**Amended Concept Proposal for the Redevelopment of Cockle Bay Wharf  
Notification of Exhibition (SSD 7684)**

Thank you for your letter dated 14 November 2017, requesting Transport for NSW (TfNSW) to review and comment on the above. Roads and Maritime Services will provide a separate response.

## **TAB A – Detailed Comments on the Amended Concept Proposal for the Redevelopment of Cockle Bay Wharf**

**14.5m BUS VEHICLE SWEEP  
 PATHS**

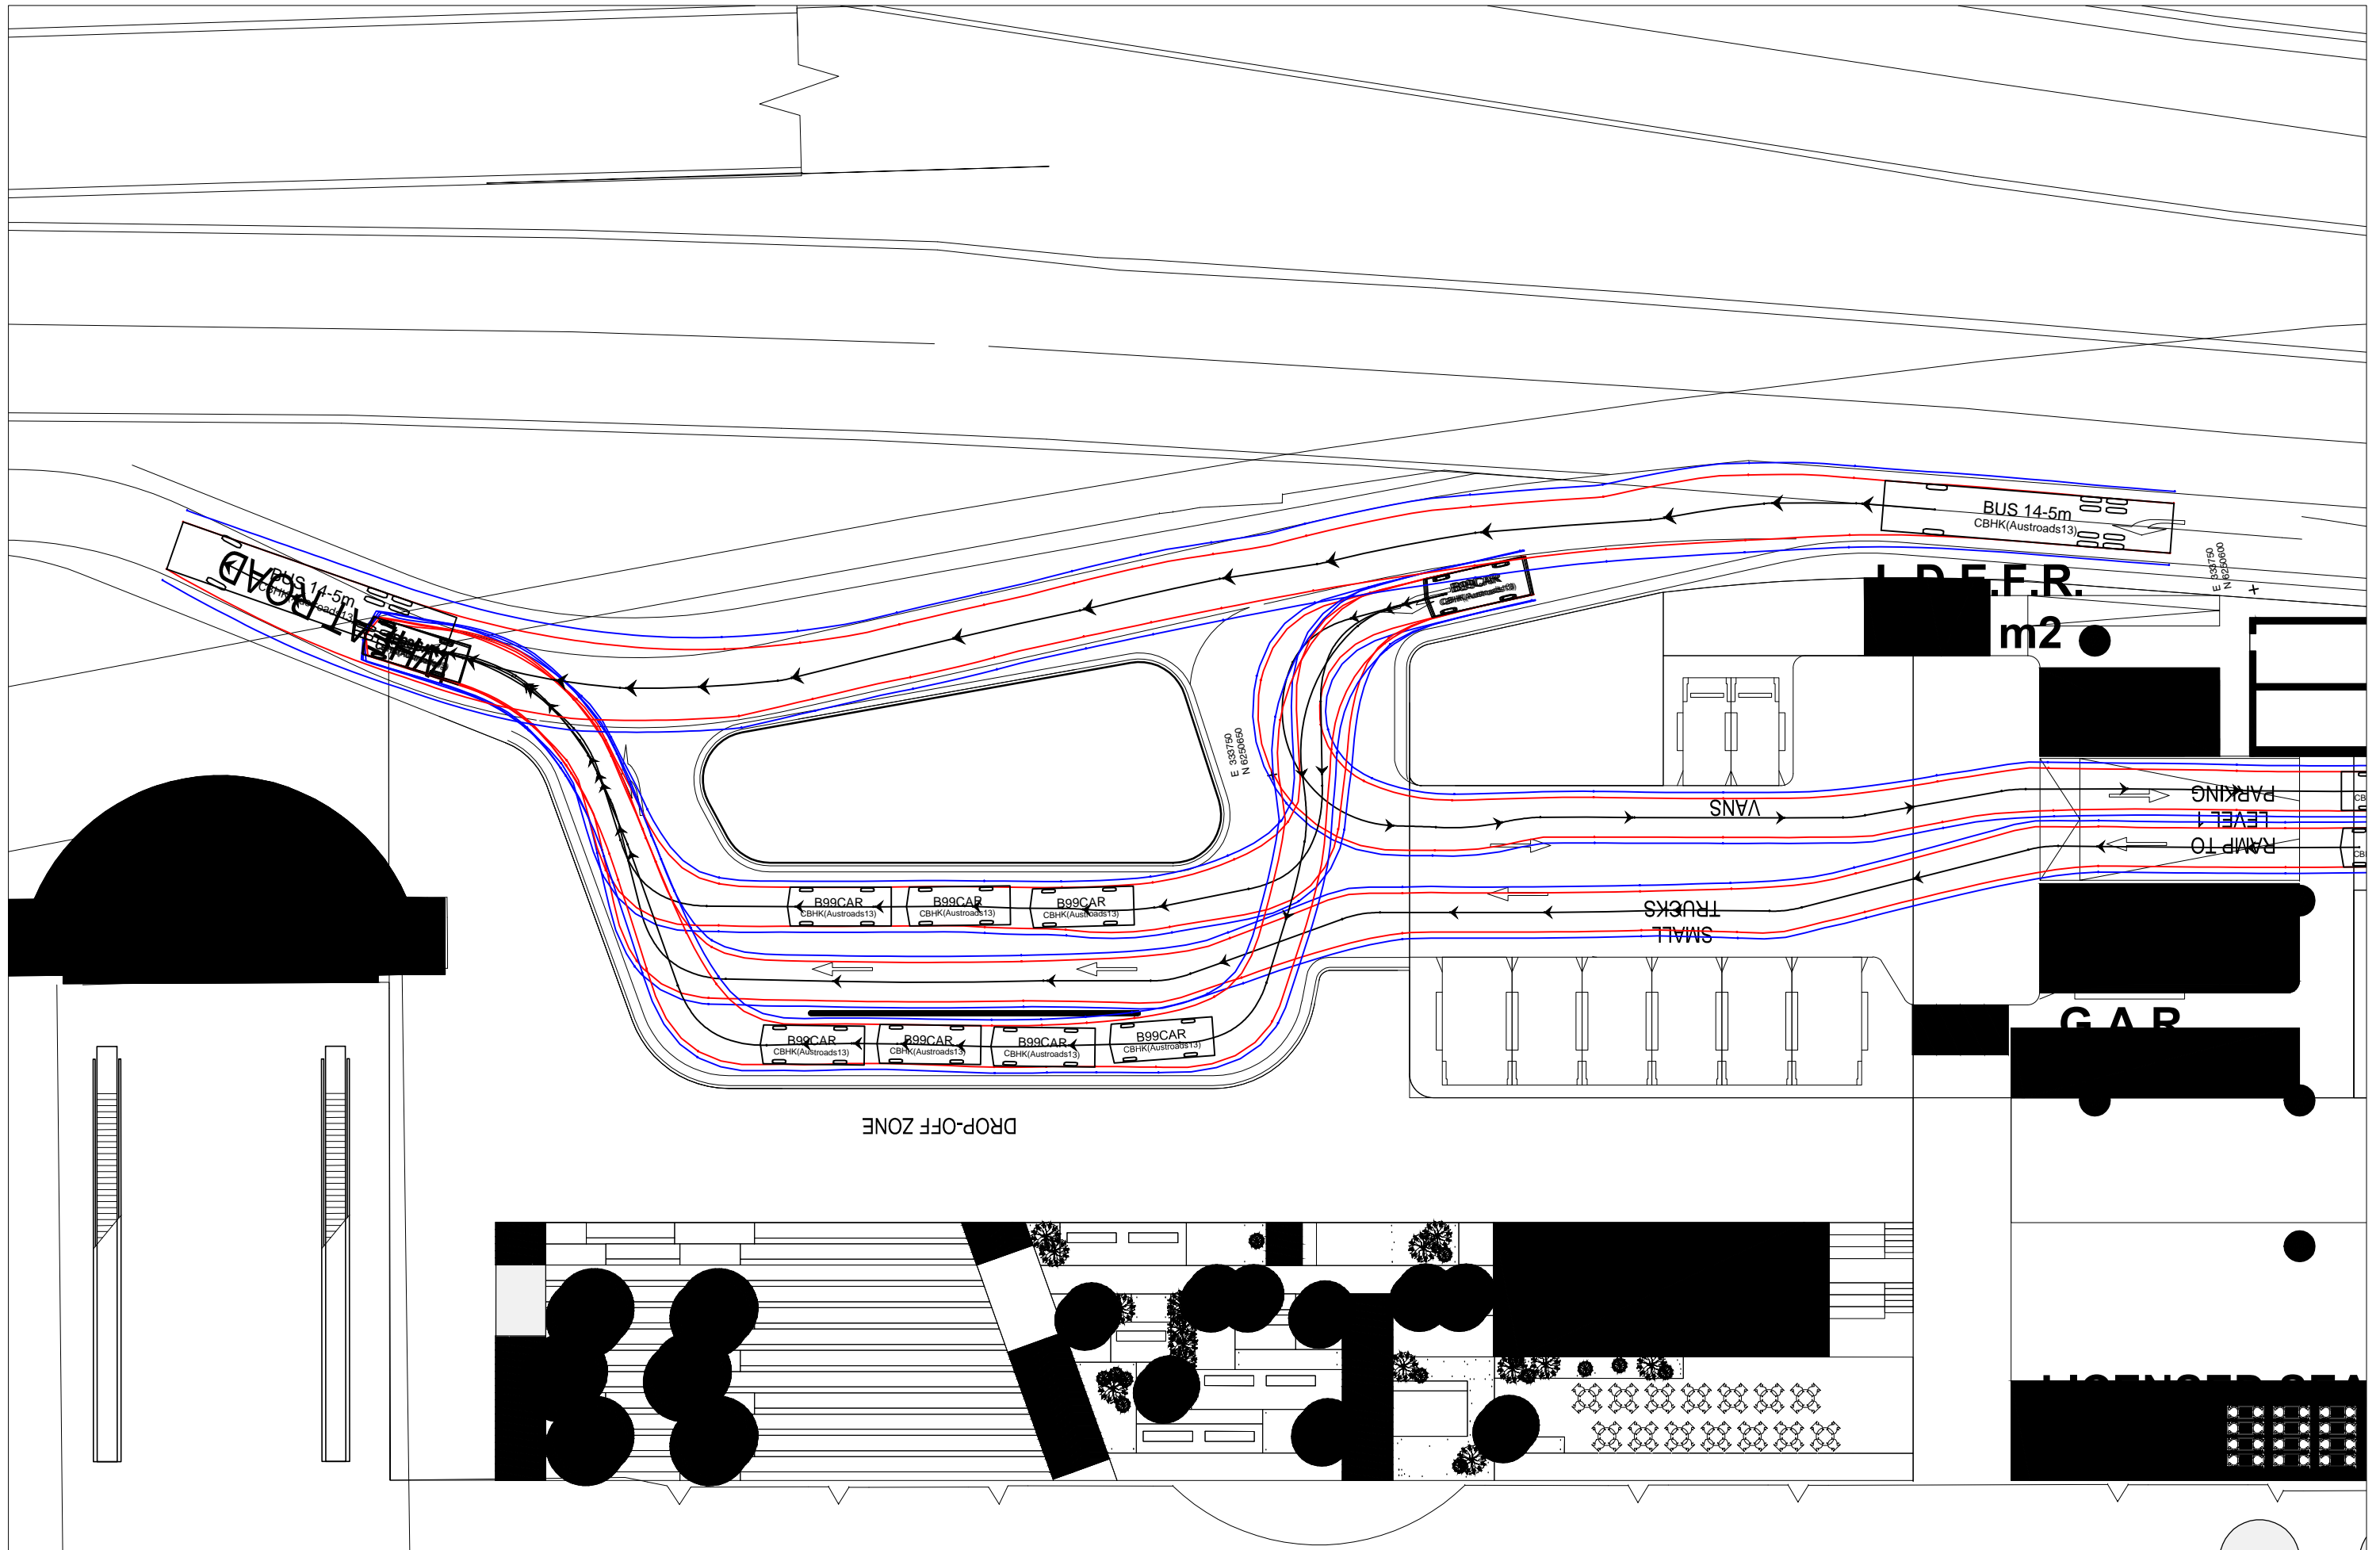
- The proposed left turn ingress into Wheat Road and associated modifications to the approved IMAX Theatre development's Porte Cochere and parking arrangement, as part of the proposed options for either a signalised left turn or left and right turn egress from Wheat Road to Harbour Street, do not align with the altered design and operation of the IMAX Theatre development's Porte Cochere and parking arrangement; and
- It is unclear if the proposed modifications to the approved IMAX Theatre development's Porte Cochere and parking arrangement also form part of the proposed priority controlled left-only turn from Wheat Road onto Harbour Street, as the vehicle swept paths provided at Attachment B are based on the proposed modified Porte Cochere and parking arrangement design.

- Any proposed changes to Wheat Road and the Wheat Road/Harbour Street intersection as part of the subject proposal align with the IMAX Theatre development and be investigated by a road safety audit that should be undertaken by an independent TfNSW accredited road safety auditor;
- The applicant ensures that traffic movements from vehicles associated with the operation of the IMAX Theatre development, particularly northbound traffic on Wheat Road, are not impacted; and
- The applicant clarifies if the proposed modifications to the approved IMAX Theatre development's Porte Cochere and parking arrangement also form part of the proposed priority controlled left-only turn from Wheat Road to Harbour Street and if so, investigate the changes by undertaking a road safety audit by an independent TfNSW accredited road safety auditor.
